Hornsea Project Four

Applicant's Responses to the ExA's First Written Questions

Deadline 2, Date: 29 March 2022

Document Reference: G2.2

G2.12

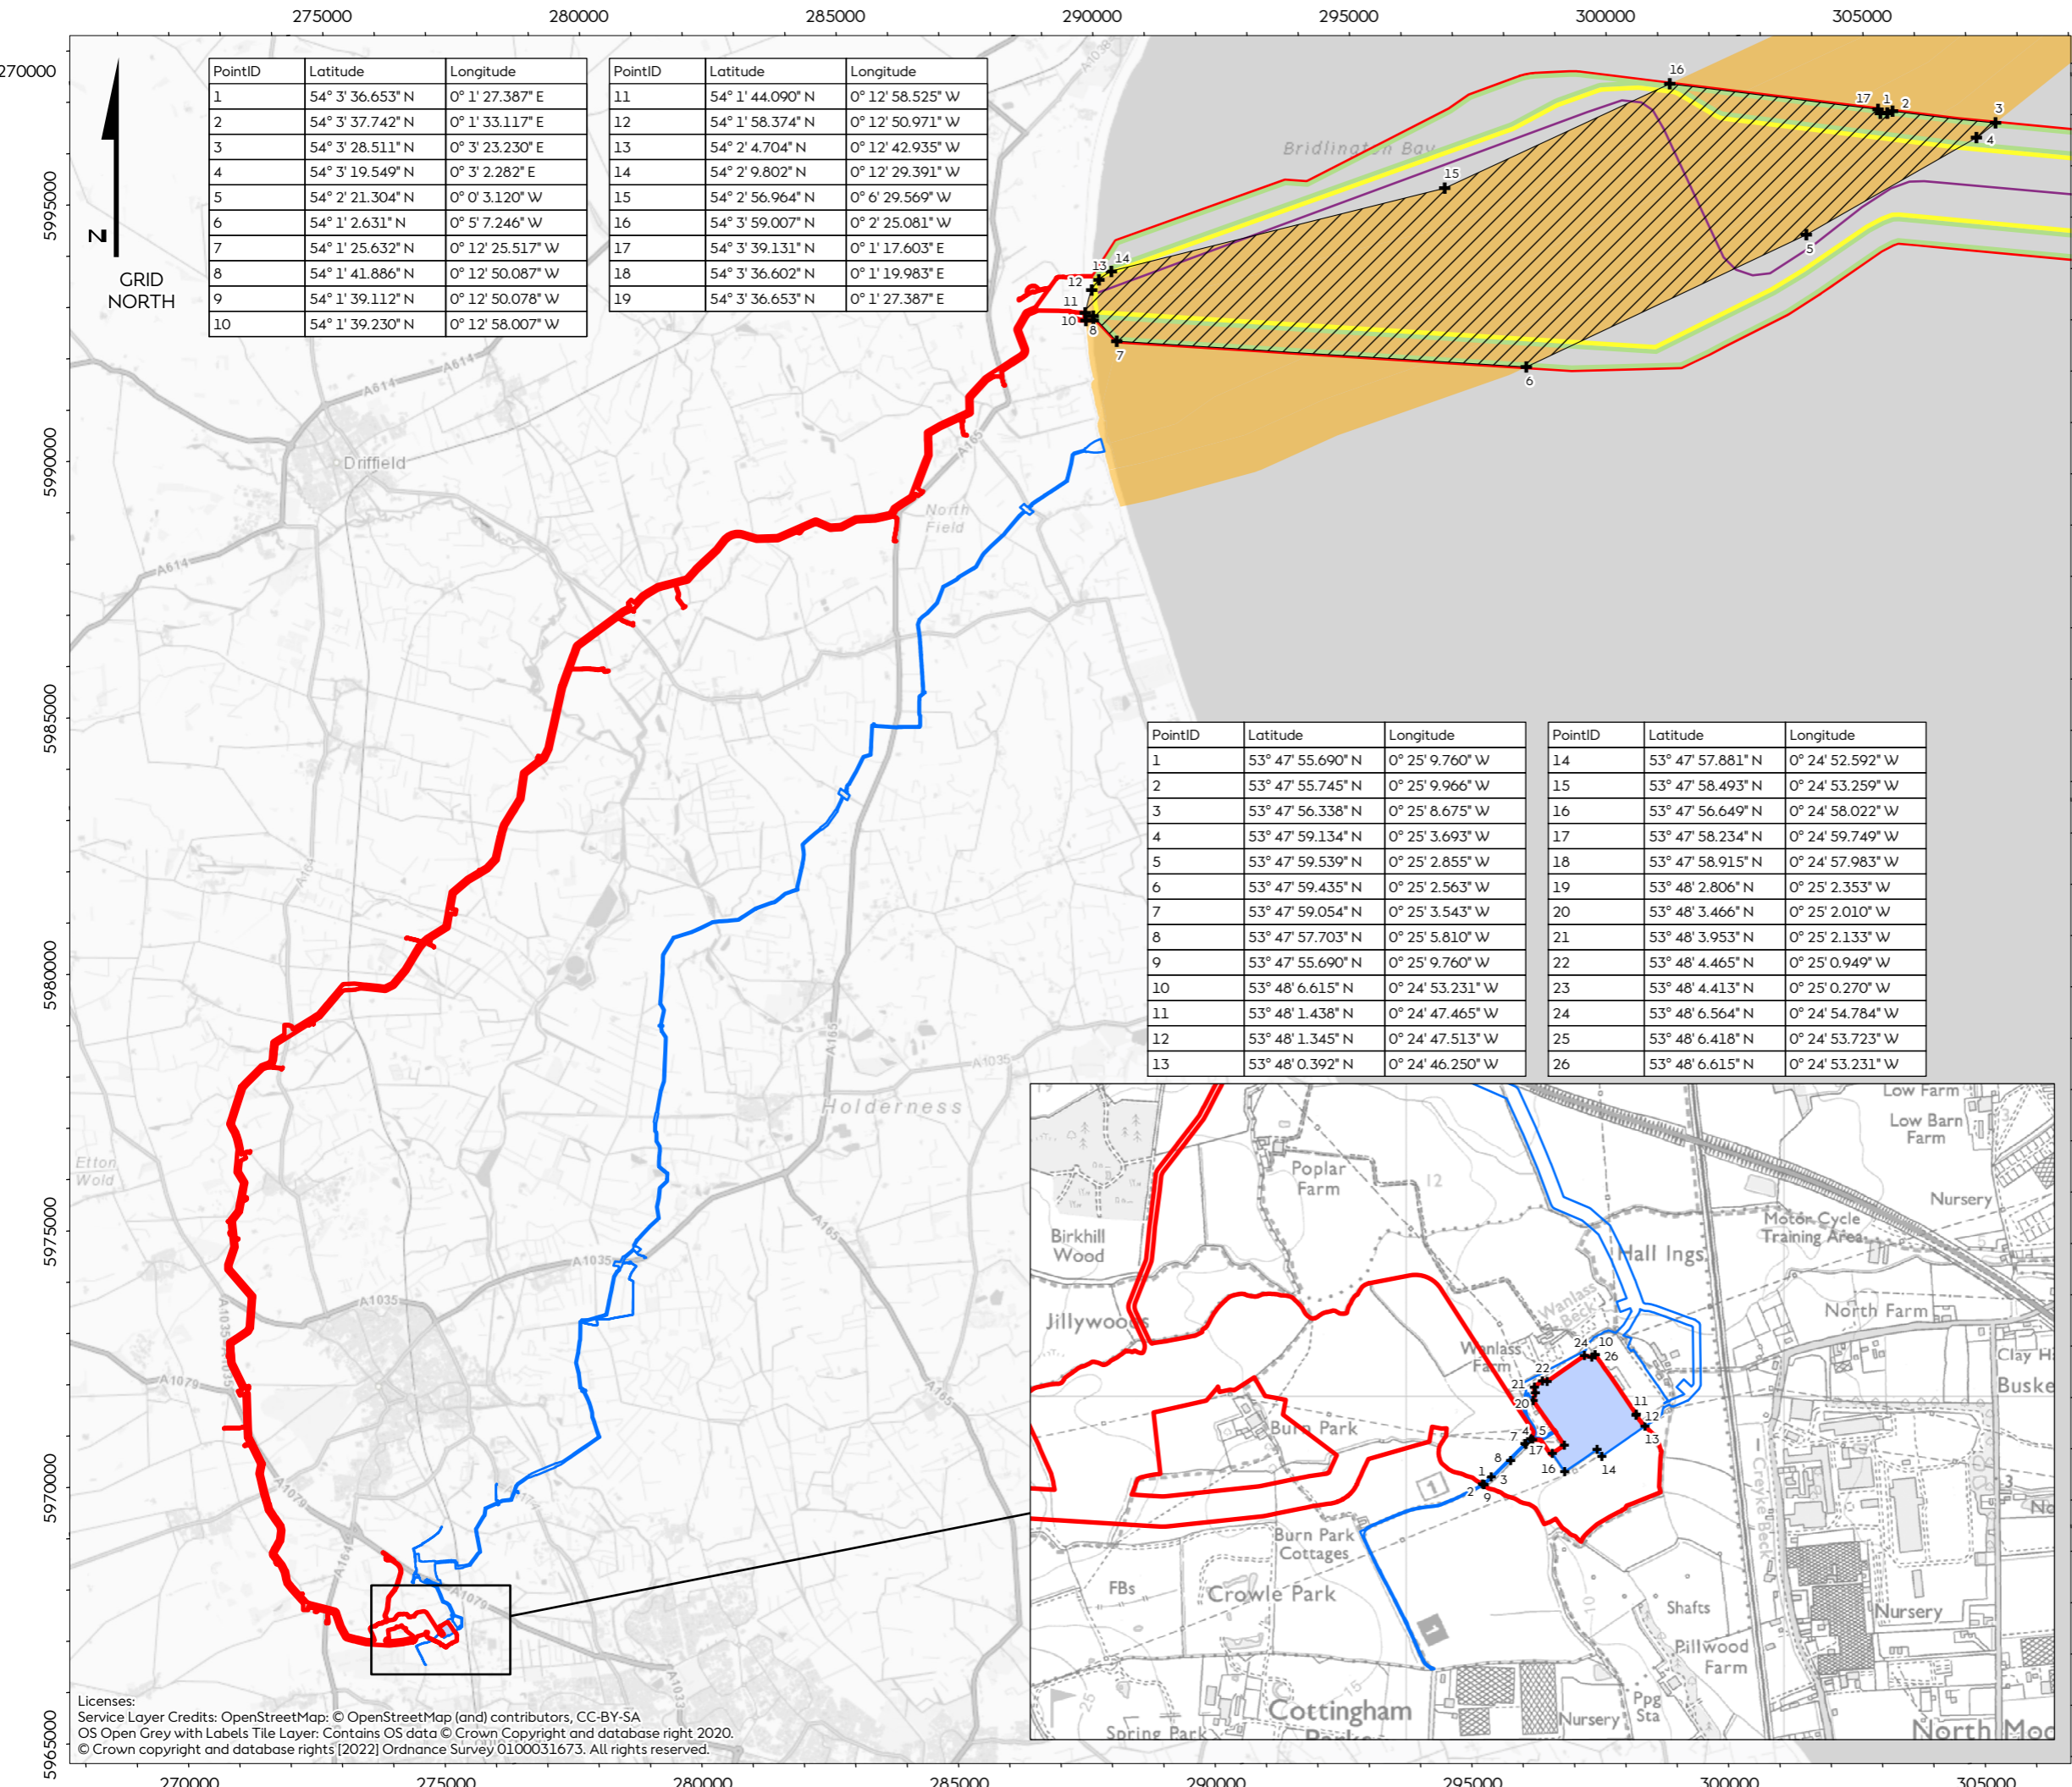
| BGC.1.1.11 | Applicant | <p>Interaction between Dogger Bank Creyke Beck DCO (DBCBC DCO) and the application</p> <p>Parts of the DBCBC DCO Order limits and the application Order limits would overlap. Would the Applicant please provide:</p> <ul style="list-style-type: none"> i. A plan showing the overlapping Order limits or signpost where in the application documents this can be found. ii. Further detail of how the two DCOs would potentially interact, including any conflict between the two | <p>The Applicant submits at Deadline 2 a plan showing the overlapping Order limits between Dogger Bank Creyke Beck DCO and the application (see G2.12: Interaction Between Hornsea Four and Dogger Bank Creyke Beck DCO Order Limits).</p> <p>In respect of overlapping Order Limits in the marine environment, the Applicant confirms disposal sites will be split to accommodate the Dogger Bank A&B ECC (intertidal and offshore). This will be done by excluding the Dogger Bank A&B disposal sites from the defined disposal sites for the Proposed Development. The draft DCO marine disposal sites will be updated at Deadline 2 accordingly (see RR-020-3.3.16 at Deadline 1 in G1.9: Applicant’s comments on Relevant Representations (REP1-038)). In respect of overlapping Order Limits onshore, it is noted that the projects interact at the existing Creyke Beck National Grid Electricity Transmission (NGET) substation and the Dogger Bank construction access road along Park Lane.</p> |

| | | | <p>The Applicant confirms there is no potential for this overlap to cause adverse implications on either projects due to the type of overlap and the timing of each project’s construction programme, which are not envisaged to overlap.</p> |
